## Office of Environment & Heritage

Our Ref: DOC18/529521

Your Ref: SSD 8169

**Re: Environmental Impact Statement – State Significant Development 8169 and Modification 3 of Major Project 09\_0028 (Concept Plan) for North Byron Parklands Cultural Events Site, Yelgun**

SECURITY FENCING DETAIL

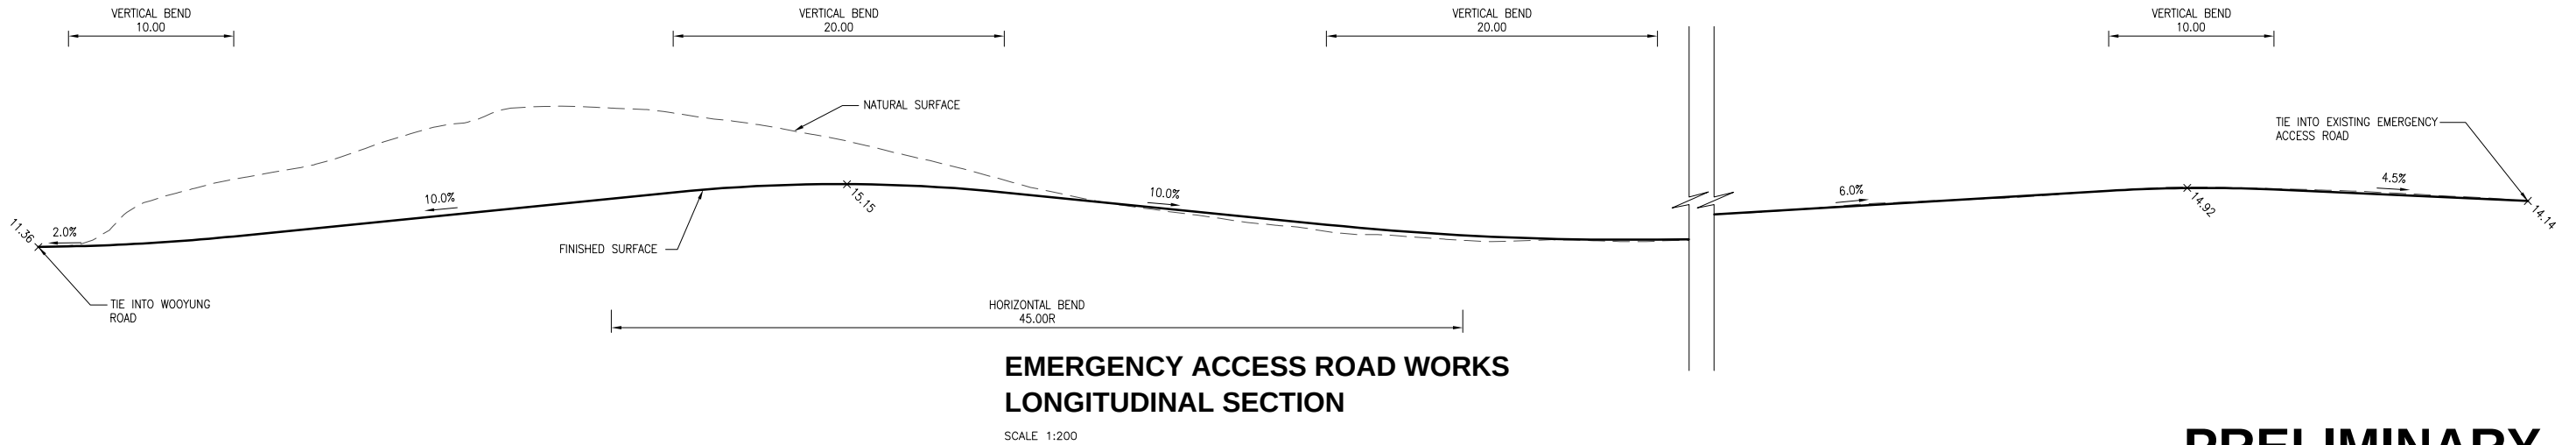
Chapter 4 also states that *"koalas are likely to move away from disturbance during events and good connectivity is available adjacent to areas of disturbance"*. Firstly, the KPoM does not discuss any outcomes from the ongoing ecological monitoring program supporting the premise koalas move away from disturbance. Secondly, given that remnants of koala habitat are scattered amongst the various event areas within the securely fenced precinct, it is unclear how displaced koalas could safely evacuate disturbed areas. It appears any koala attempting to flee from disturbance would have to traverse parkland and/or cleared areas swarming with patrons before attempting to climb over the security fencing. Furthermore, it is unclear if the design of the proposed security fencing will allow safe and easy traversing by koalas.

12. Revise the KPoM to include well-considered, detailed mitigation measures for effectively managing koalas within the securely fenced precinct displaced by event disturbances. The focus of mitigation should be on pro-active measures rather than reactive responses (e.g. conduct pre-event searches in koala habitat remnants within the securely fenced precinct to identify and monitor resident koalas likely to be affected by event disturbances).
13. Revise the KPoM to include detailed illustrations of the proposed permanent and temporary fence designs.
